Item No. **Report of the Head of Planning, Building Control, Sport & Green Spaces**

Address LAND ADJACENT TO 171 NORTH HYDE ROAD HAYES

Development: Erection of two storey building comprising ground floor shop, two bedroom flat at first floor level and associated parking (Part Retrospective)

LBH Ref Nos: **11980/APP/2015/1160**

Roof Plan

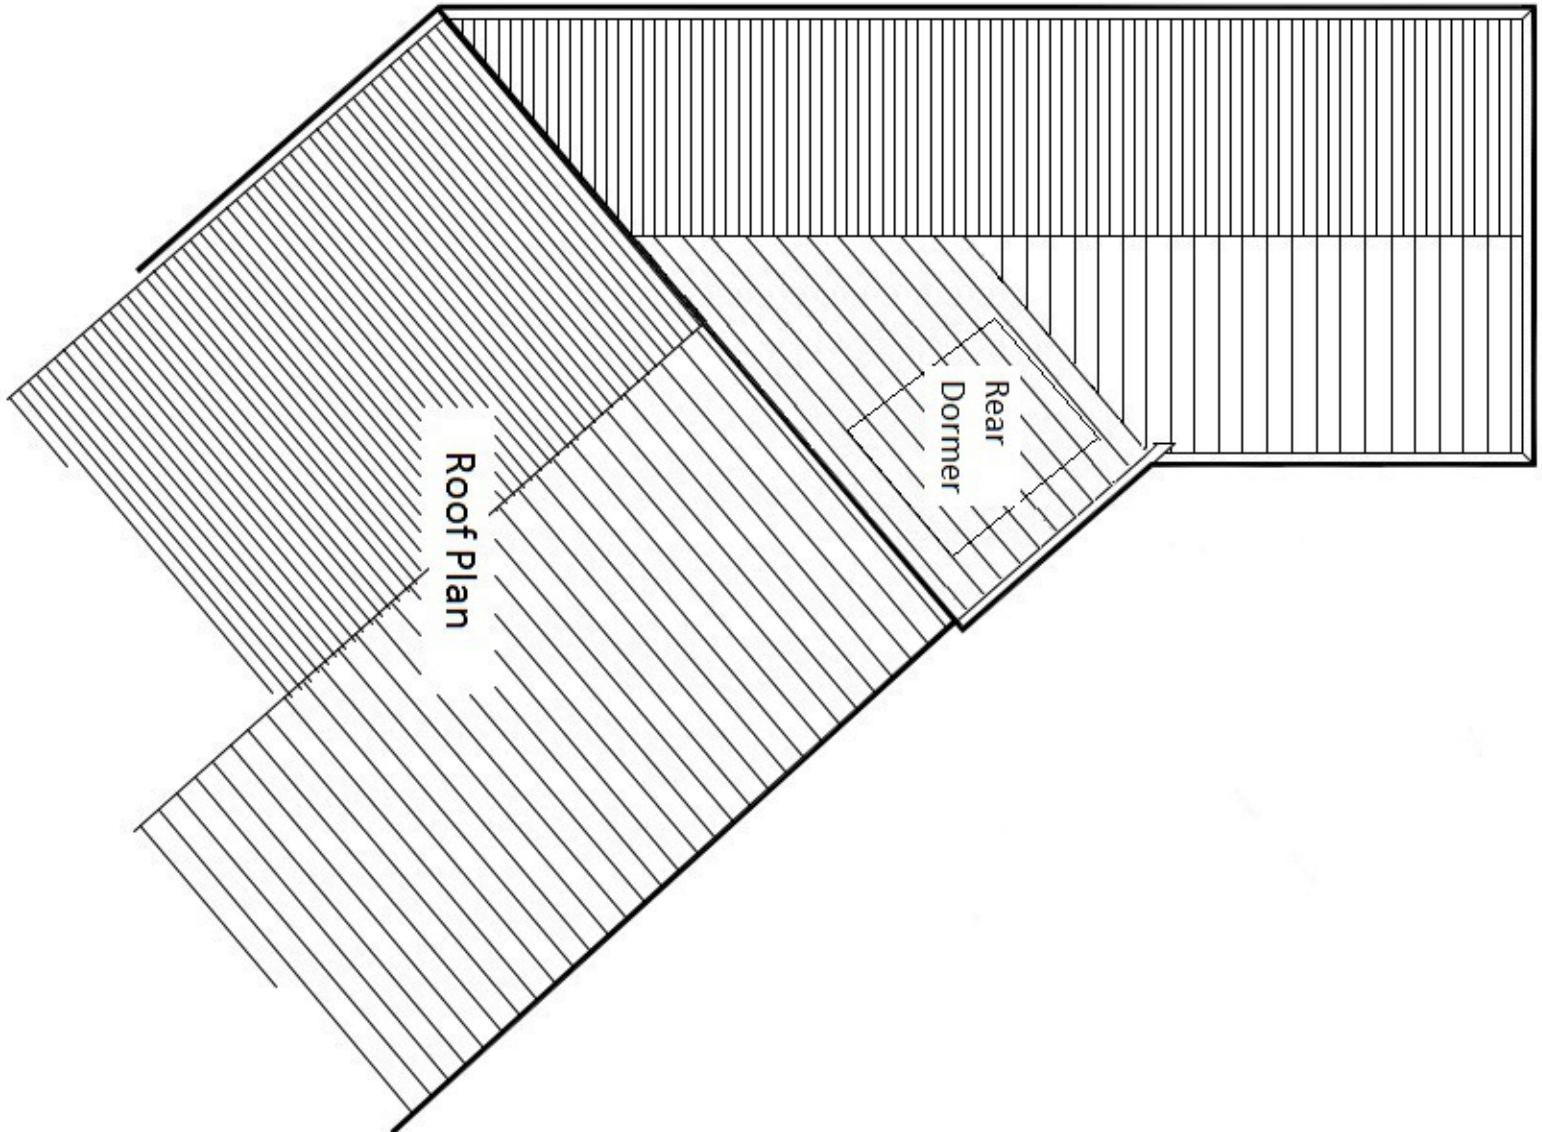
The application is a re-submission of a previously allowed scheme 11980/APP/2012/708 - granted permission on 28/05/2012). However the scheme built does not equate to the approved drawings and several unauthorised alterations were made. The existing plans show what has been built and the proposed plans now show what is acceptable to the LPA and these have taken several revisions. The scheme is recommended for approval subject to the revisions and the removal of the unauthorised rear dormer, first floor side gable window and the walls and gates around the car port.

The previous application provided 2 open ended car port spaces for 2 covered spaces for the first floor flat. On the sides of the car port was shown an open area with railings which provided visibility as well as security. this arrangement was approved. However, the applicant inserted windows into the areas where railings had been agreed and extended the carport with a 2m high wall on both sides to the service road installing timber gates effectively closing in the carport area. The applicant has stated that this is for security purposes as builders materials and equipment were constantly being stolen and also for the increased security of the future tenants.

However, the walls and the gates are considered to reduce visibility significantly when existing the carport and the Highways officer recommended a refusal based on highways grounds. In previous correspondence stating:
